WEST SUSSEX COUNTY COUNCIL CONSULTATION

TO:	Arun District Council FAO: Anita Gardner
FROM:	WSCC - Highways Authority
DATE:	31 December 2020
LOCATION:	Rear of 43 Old Manor Road Rustington West Sussex BN16 3QS
SUBJECT:	R/238/20/PL Demolition of existing garage & erection of cabin in rear garden as dwelling. This site is in CIL Zone 4 and is CIL Liable.
DATE OF SITE VISIT:	n/a
RECOMMENDATION:	More Information
S106 CONTRIBUTION TOTAL:	n/a

C			
B			
A			
Client	S. Hampton Esq.		
Address	R/O 43 Old Manor Road: Rustington		
Drawing	Additional plans	No. 4120:2	
Scale	1:200 1:500 1:1250	Drawn	B
Date	NOV '12

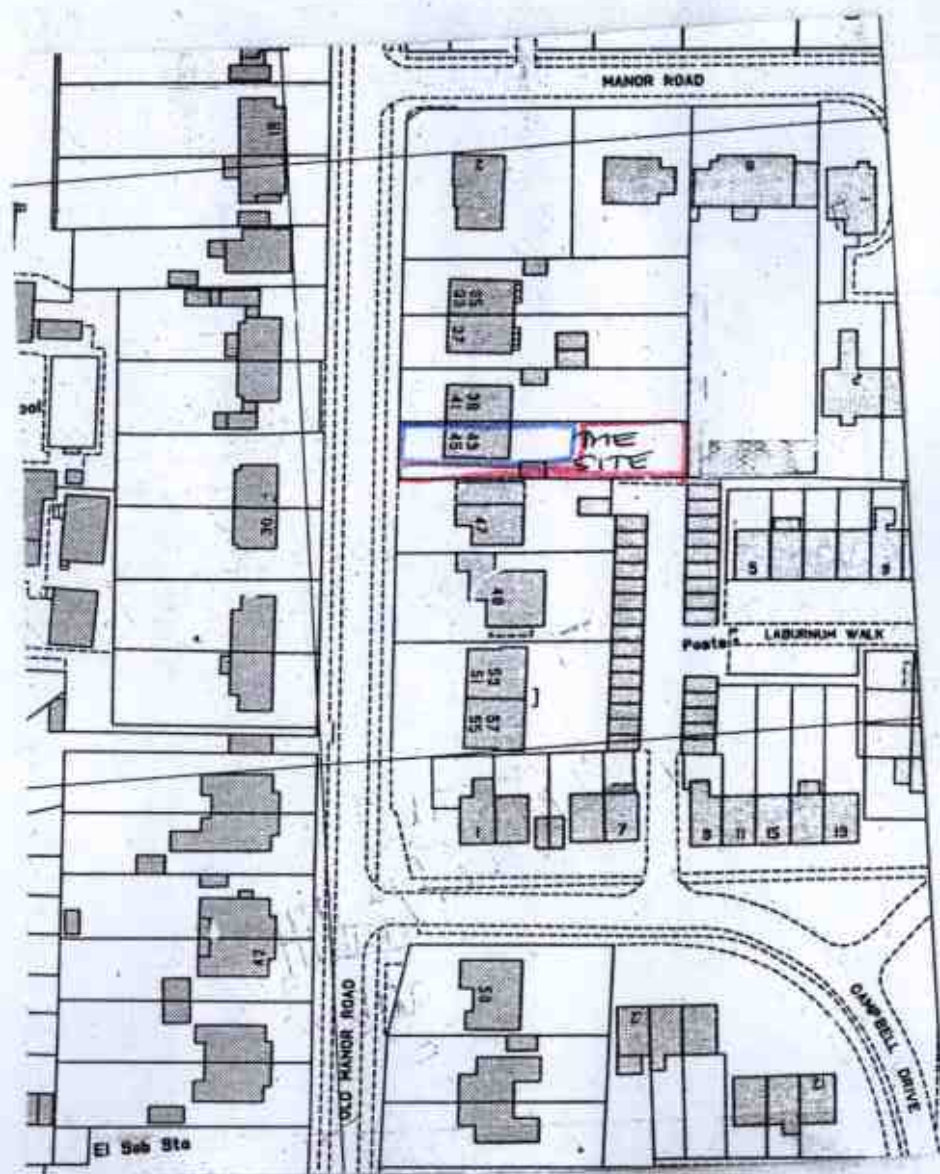
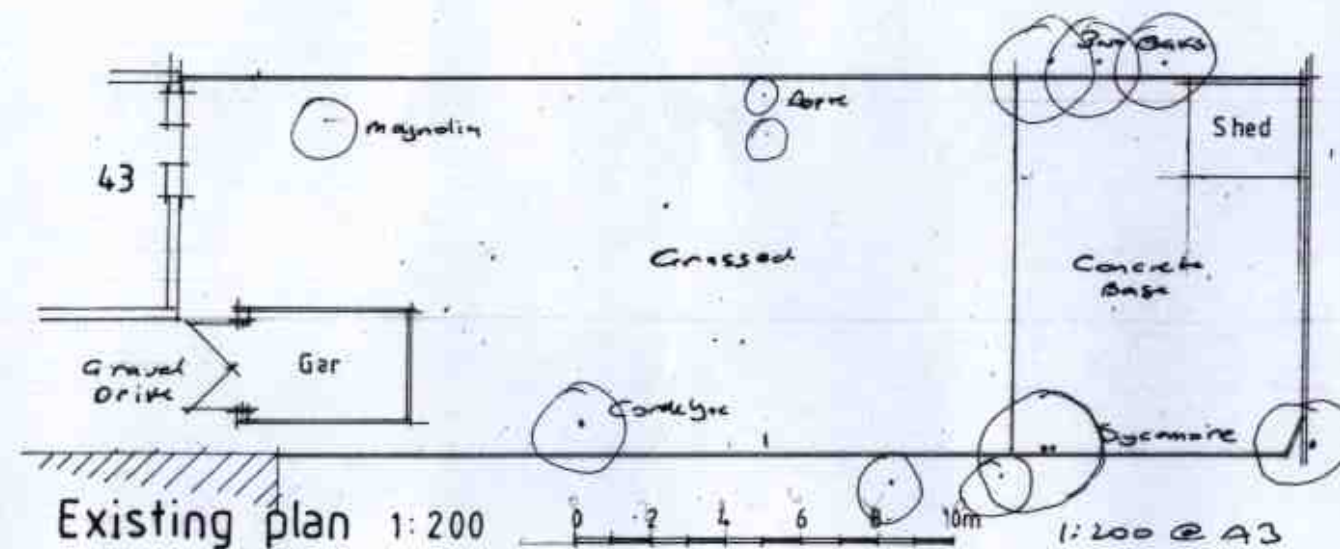
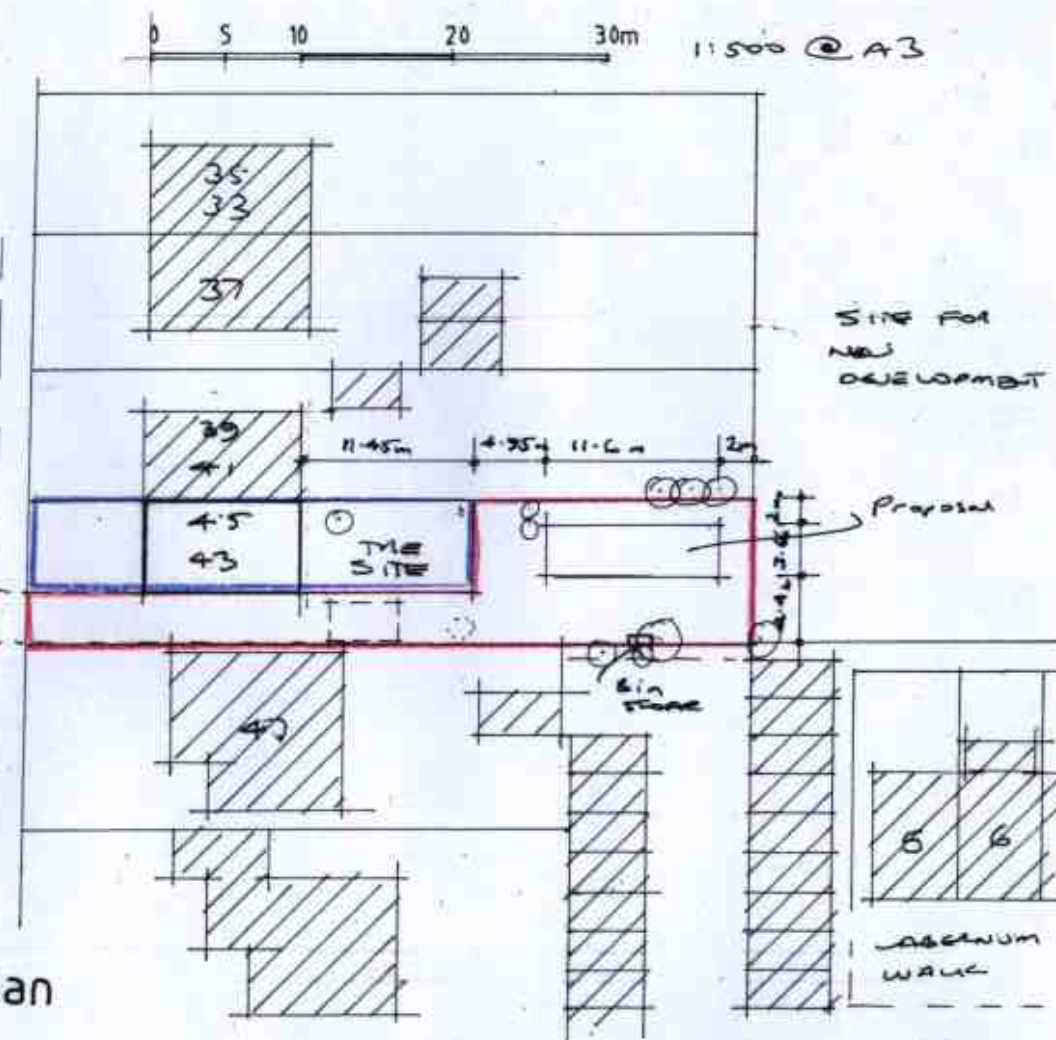
Please provide plans that clearly show the existing and proposed parking provisions of the site.
